## Application for a Non-Material Amendment Following a Grant of Planning Permission

A single storey rear extension, increased vehicular crossing and provision of off-road parking and detached garage.

PF/23/0825

The approved detached garage to the front garden is moved from the agreed western boundary to the opposite eastern boundary, as illustrated.

PROPOSED SITE PLAN.
AMENDED TO SHOW GARAGE MOVED TO EASTERN BOUNDARY.
1:100 SCALE.

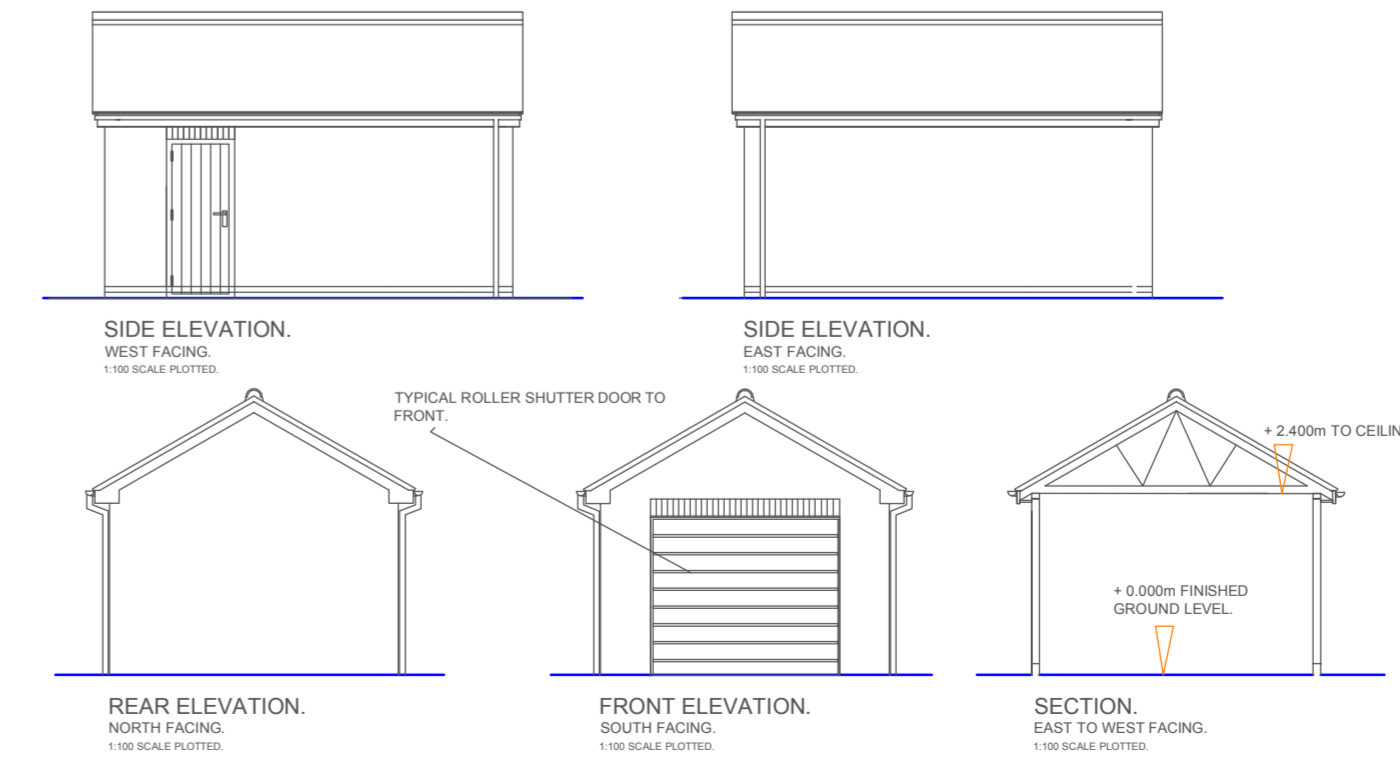
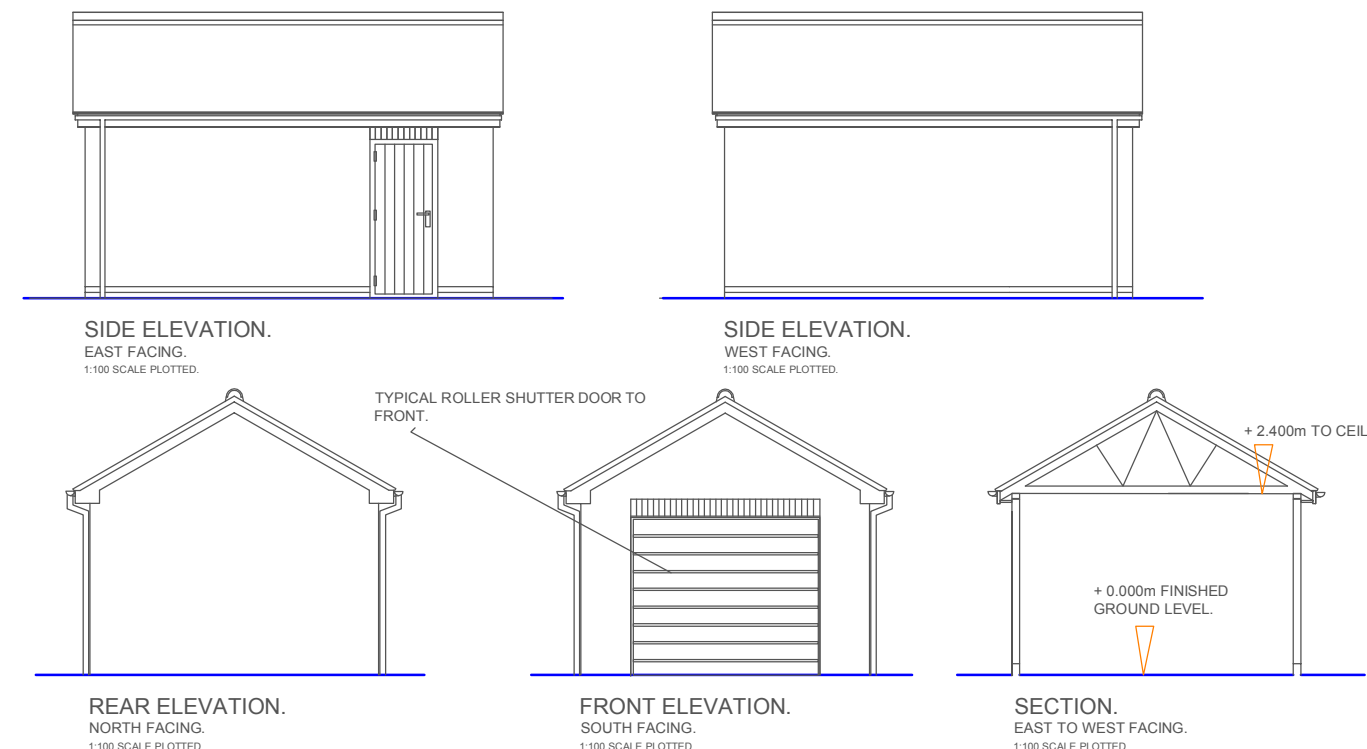
An act to appease the adjoining neighbour to the west, who aired concerns during the previous planning application consideration but these concerns were overruled by the granting of planning consent.
